## **OXFORDSHIRE COUNTY COUNCIL'S RESPONSE TO CONSULTATION ON THE FOLLOWING DEVELOPMENT PROPOSAL**

**Application no:** 21/01119/OUT

**Proposal:** Outline planning application for the re-development of the Banbury Oil Depot to include the demolition/removal of buildings and other structures associated with the oil depot use and the erection of up to 143 apartments and up to 166m<sup>2</sup> of community and/or retail and/or commercial space (Class Use E and/or F2) with all matters (relating to appearance landscaping, scale and layout) reserved except for access off Tramway Road

**Response date:** 16th March 2022

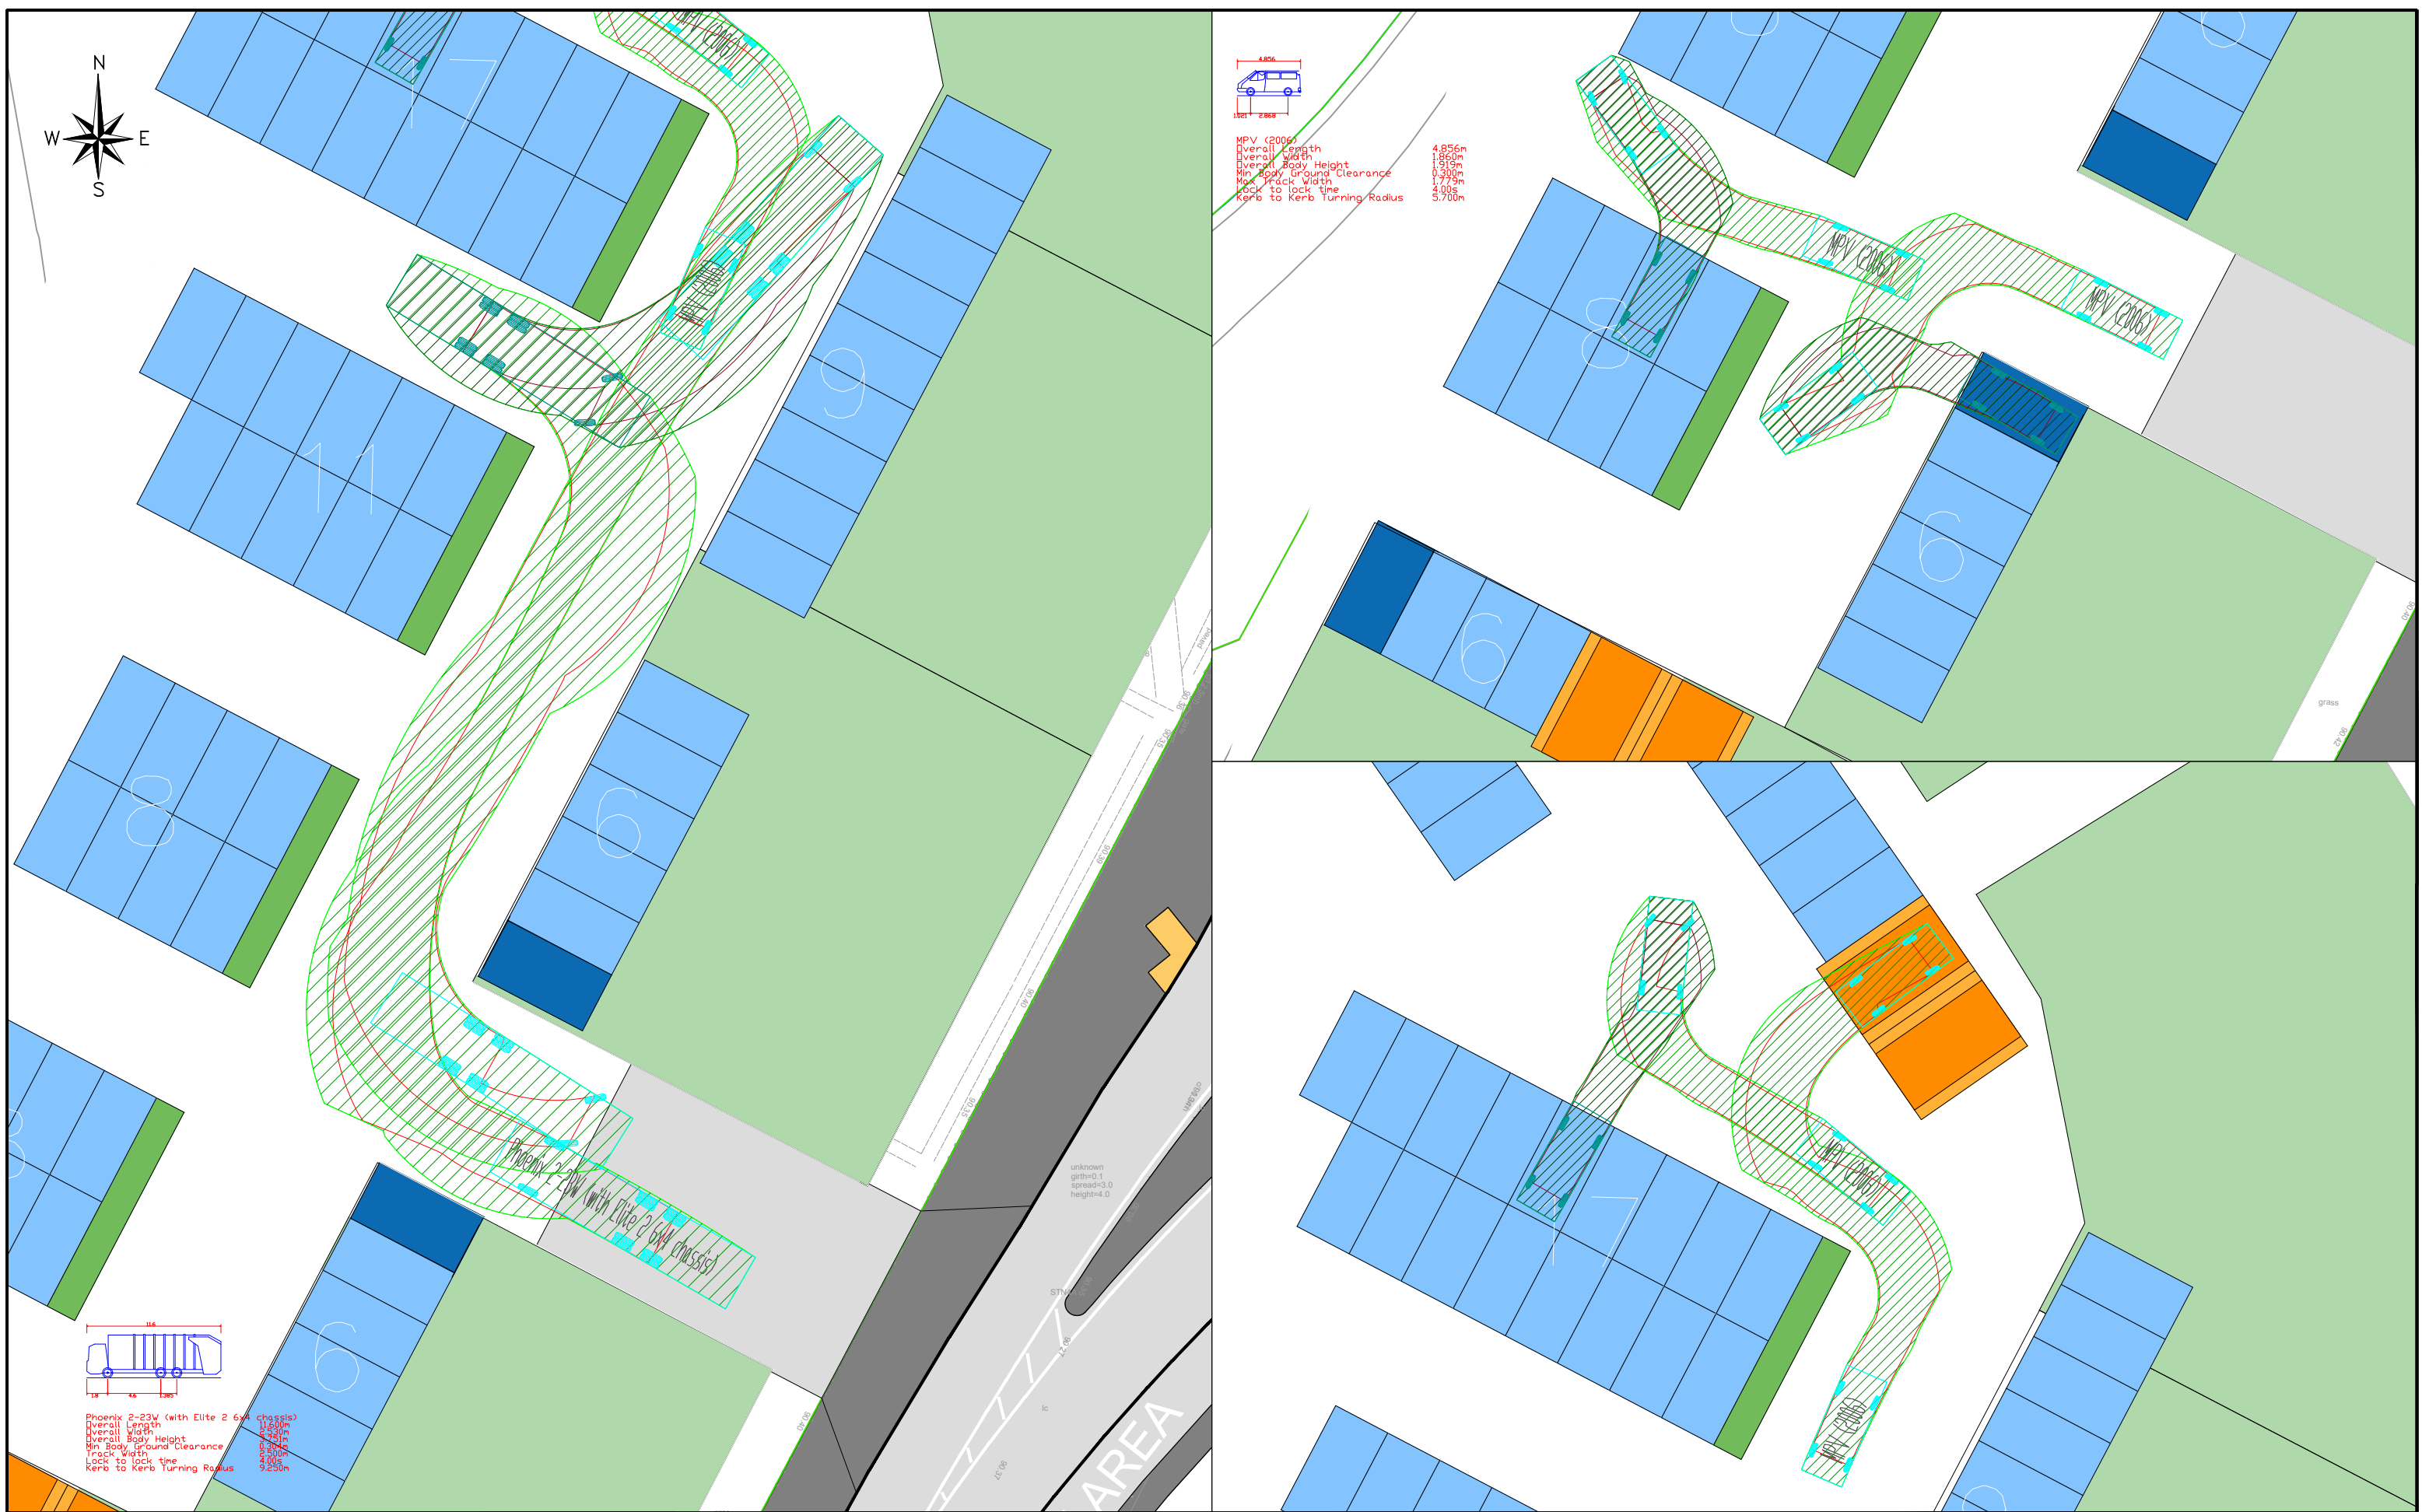
The Applicant have provided the footway previously requested to link to the station. The new access visibility splay has however not been provided. It should be also noted that OCC would not want to adopt excessive widths of footway/cycleway, (some sections are 5m widths). The bellmouth access is not very well designed for 2way access and egress movements and therefore unacceptable. The proposed access it is not wide enough to accommodate the vehicle tracking of the Refuse Vehicle in the submitted drawing. To prevent vehicle overruns of the opposite lane, the access radii should be increased, and junction widened. There are solid lines in the centre that should not be crossed.

Minimum width of access road should be 5.5m, please refer to the OCC Design Guide (2015) Section 5 Road Types.

There are no visibility splays indicated. Junction and Forward Visibility Splays must be in accordance with the OCC Residential Design Guide Second Edition (2015) and dedicated to OCC if they fall out of the existing highway boundary.

The road that the proposals connect on to is not currently highway. OCC would therefore expect the Applicant to provide a revised new access showing the required visibility splays, vehicle tracking with the access design dimensions.
